Application No: FG/94/20/HH
Site Address: 7 Little Drive Ferring BN12 5RF
Description of works: Conversion of roofspace to habitable use and conversion of roof from hip to gable end and single storey rear extension.

Thank you for your internet representation made on 21st September 2020 which has been recorded as an objection with the comments as follows:

Roof Development +
Conversion Of Existing
Conservatory, To Full
Habitable Use.
7 Little Drive, Ferring,
West Sussex. BN12 5RT

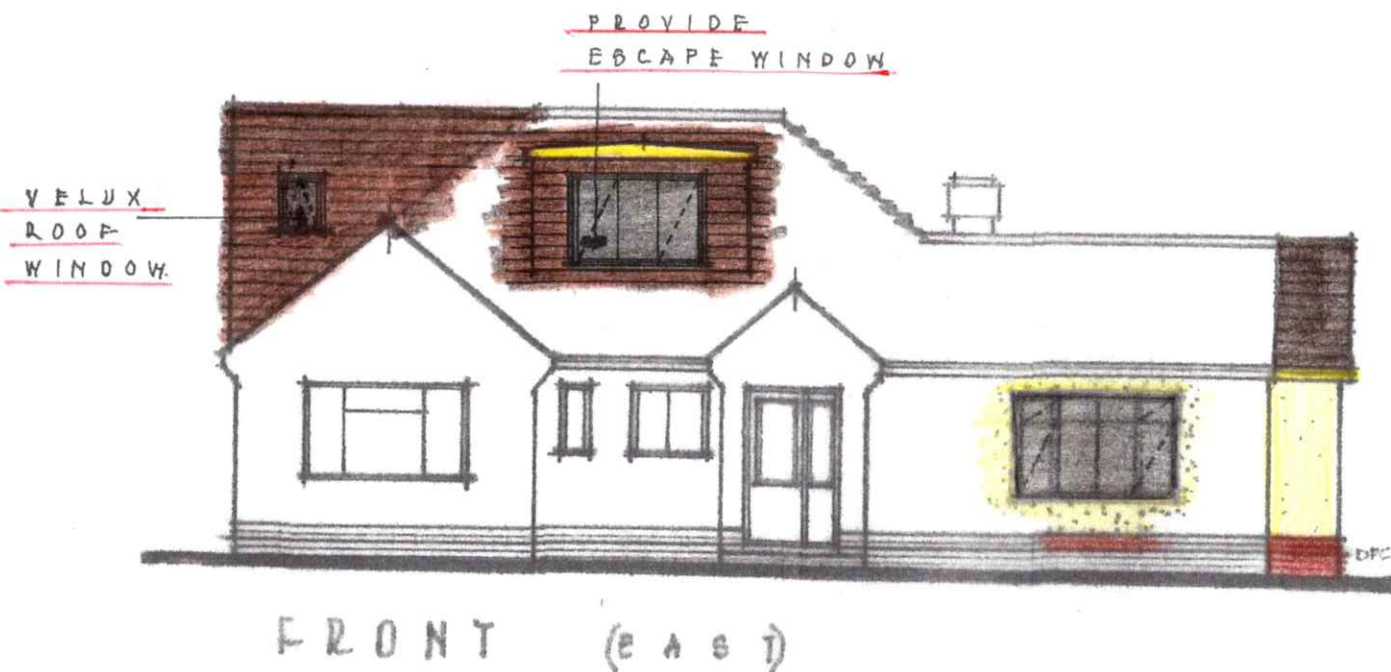
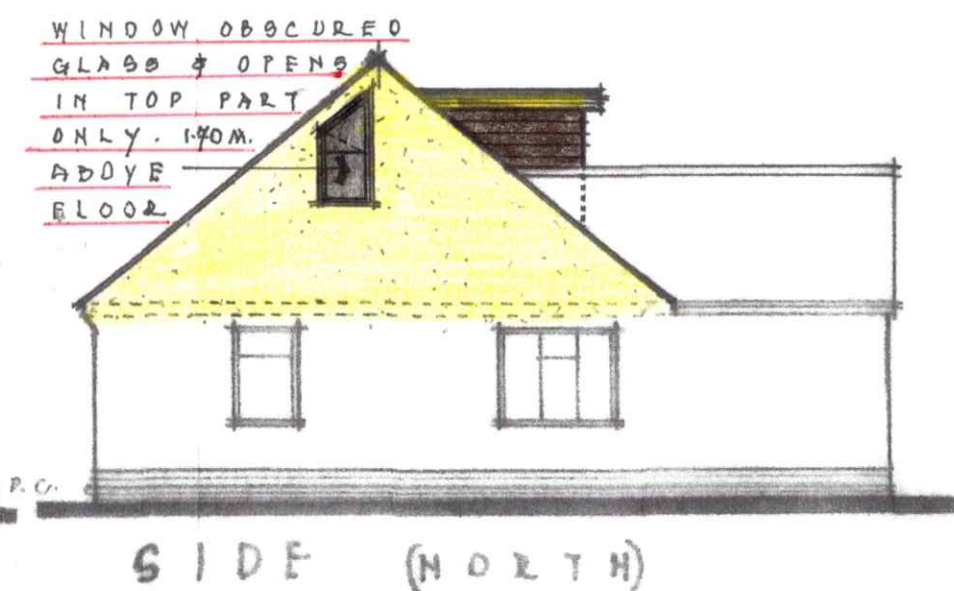
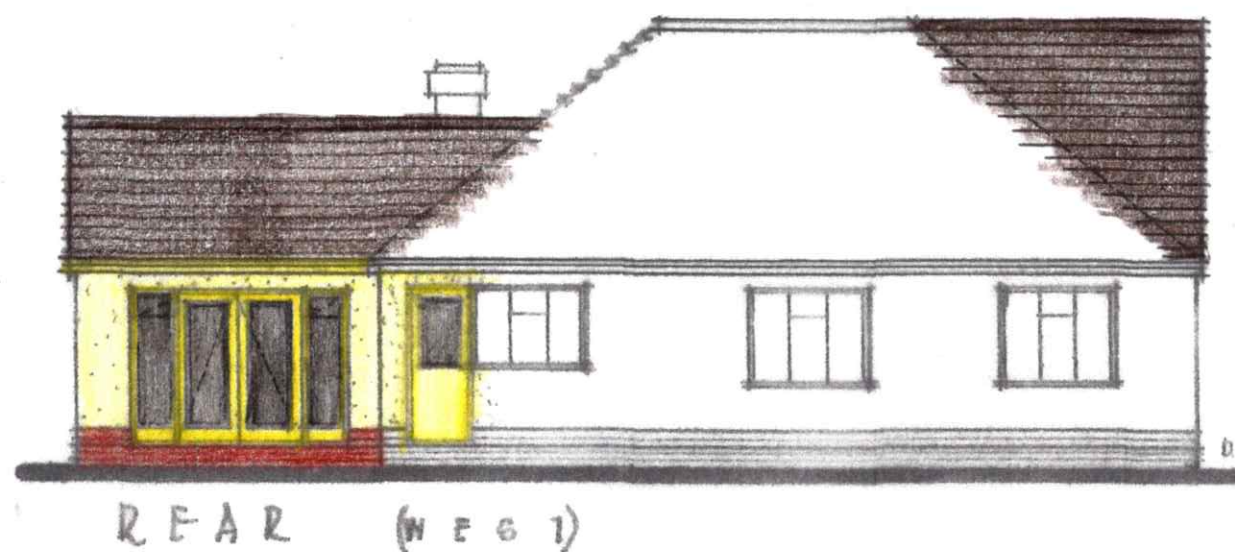
The proposed development is out of size and character of the neighbouring properties, the dormer will be directly overlooking the adjacent properties at 11 Little Drive and 14 Upper West Drive. The conversion of the hipped end to a gable end on the north elevation will also directly overshadow number 8 Little Drive and our property to the west.

Existing Plan,
Section And
Elevations Of
Property.

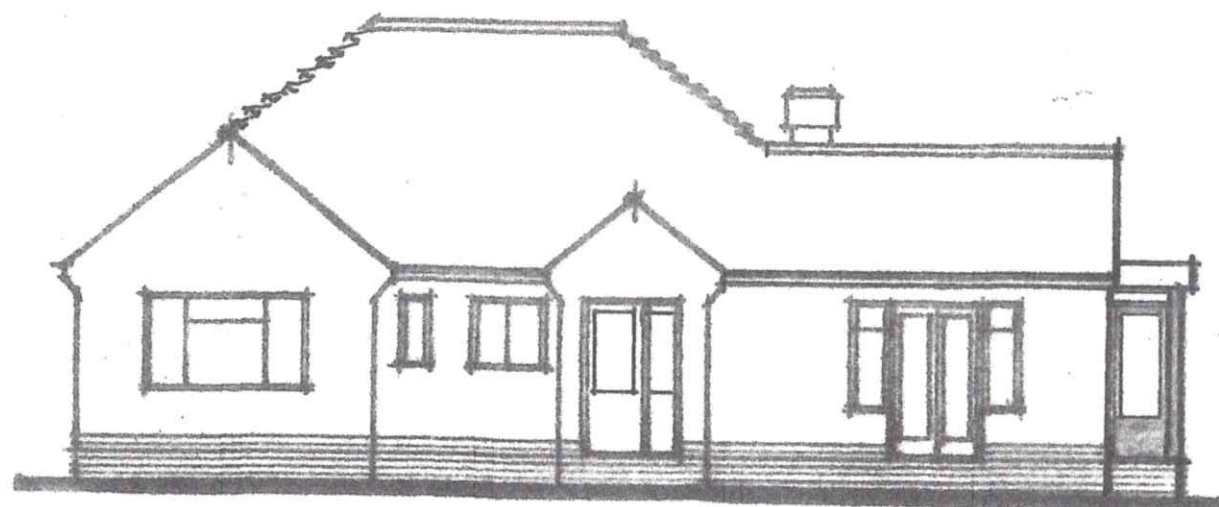
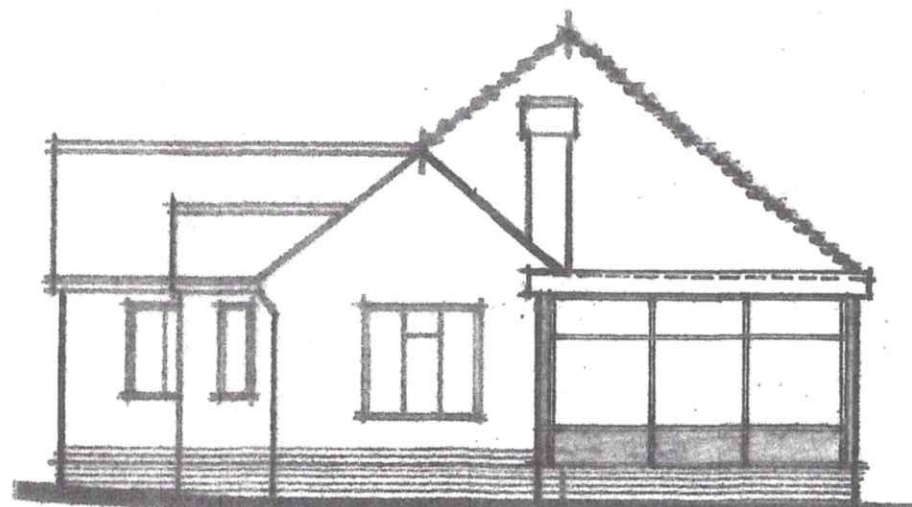
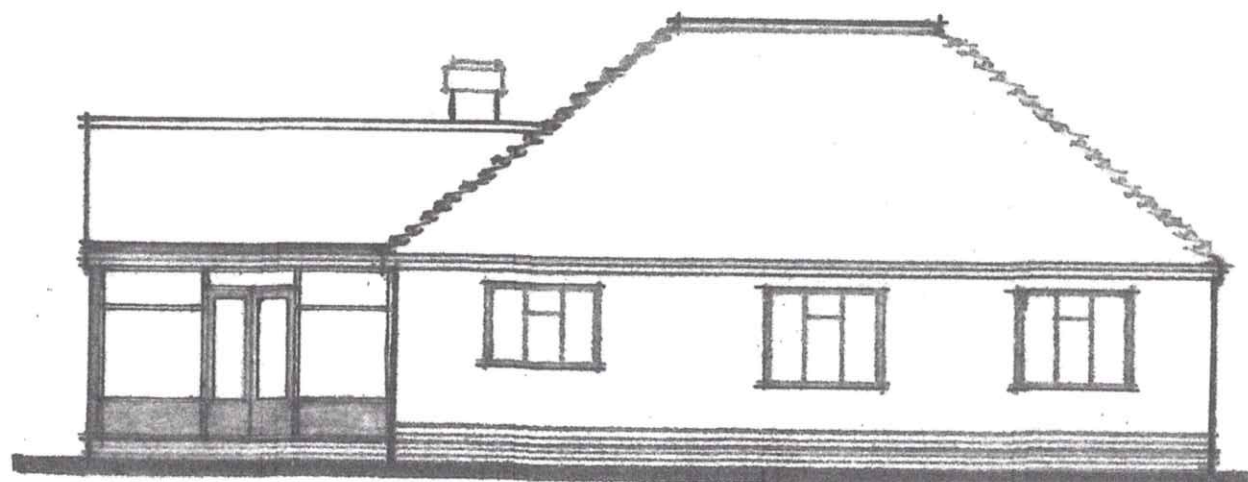
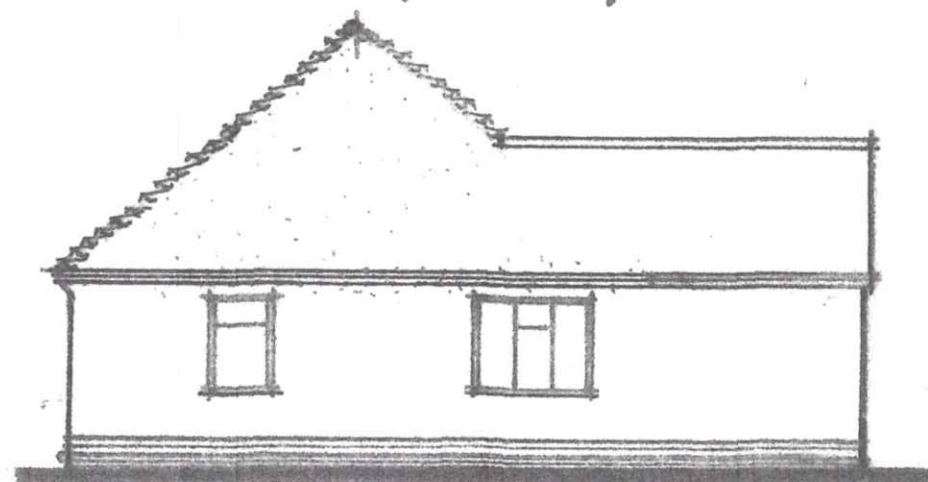
The plans submitted are not representative of the existing structure at the time of the application and the elevations are incorrectly marked. The owners of the property have already commenced works on the rear extension without planning consent. There was formerly a wooden glazed conservatory with a glazed flat roof on the south east corner of the property. This has demolished and replaced with a new extension, with concrete cavity walls and a new pitched tiled roof altering both the footprint of the building and roofline, this is not shown on their planning submission as having already being completed. The photos submitted as part of this planning application are out of date and are not representative of the actual structure at the time of this planning submission either. This would appear to be an attempt to deceive both Arun Council Planning Department and all those parties affected by the proposal. The elevation drawings have also been incorrectly labelled, the front of the property faces west and the rear is in an easterly direction, however the front is indicated as east on the plan and the rear as west.
